## COMMUNITY SERVICES DEPARTMENT

March 28, 2019

**Subject: Forest Lakes Phase II PUD Development Plan/Preliminary Plan, Review #2  
(PUDSP-18-001)**

3
10 COUNTY TRAIL- STANDARD TIER 1 DETAIL

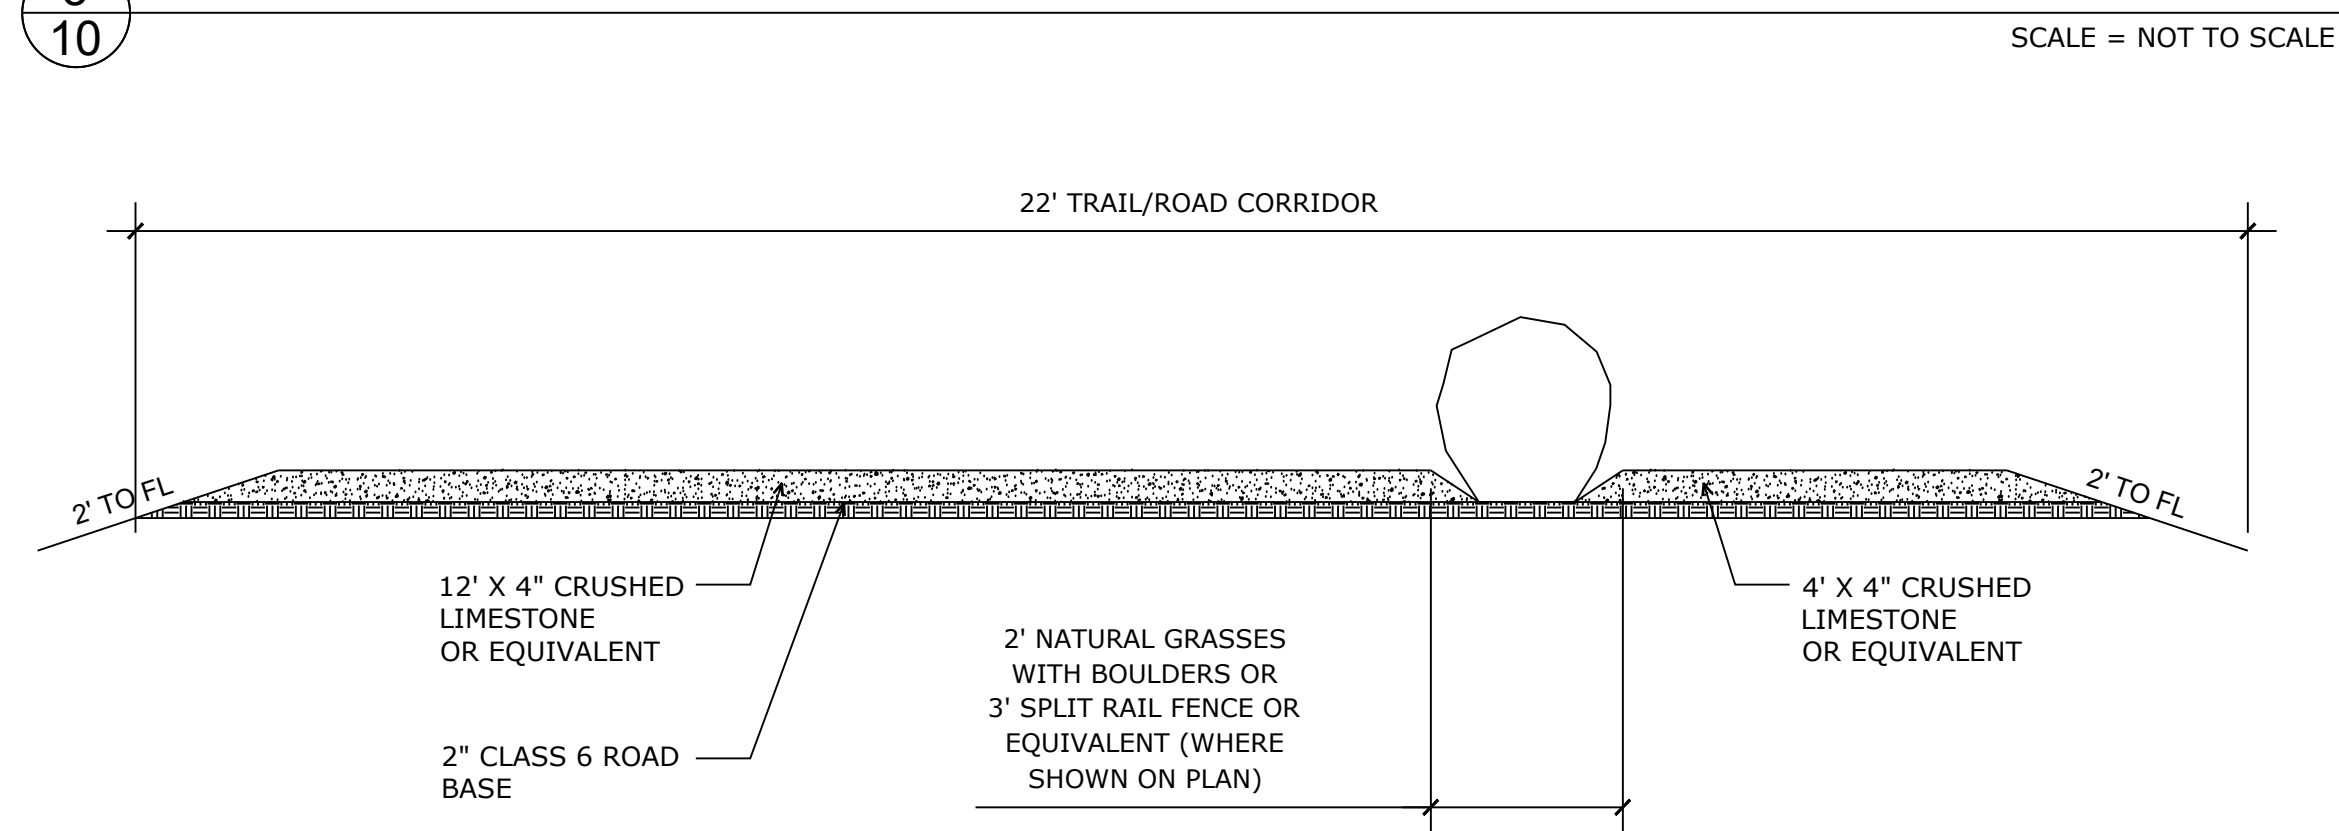
- *Trail plans shall be submitted to and approved by County Parks prior to construction.*
- *The trail shall be constructed to Tier 1 standards for a primary regional trail.*

4
10 COMBINED EMERGENCY ACCESS ROAD & COUNTY TRAIL DETAIL

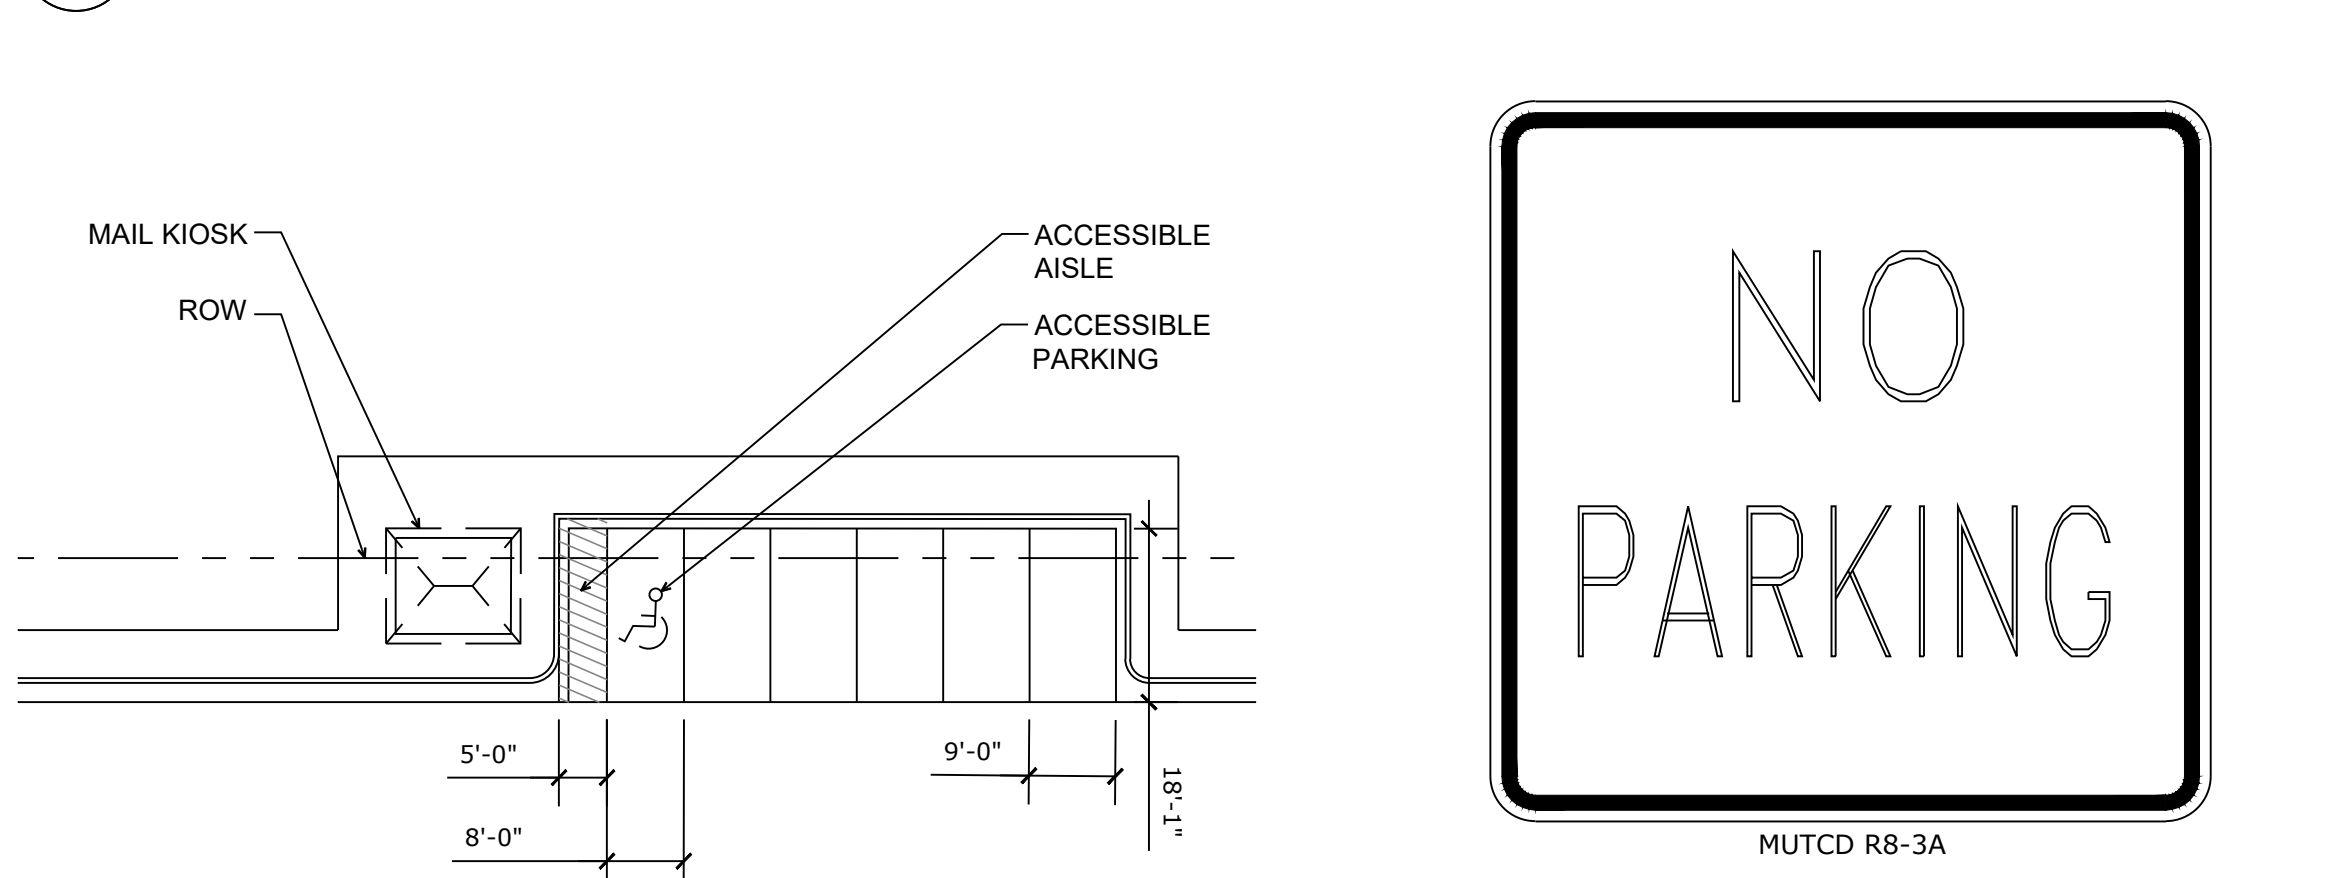
*The applicant has also requested that a portion of the Forest Lakes Secondary Regional Trail be utilized as an emergency access route. In early February 2019, Parks staff and the applicant agreed to locate the regional trail immediately adjacent the emergency access road, to be separated by boulders sourced from the site and natural grass. Where the trail and emergency road intersect local streets, a short length of post-and-dowel fencing would help to delineate the road from the trail. The details of this arrangement are notated and depicted on the attached draft Page 4 of the PUD Preliminary Plan.*
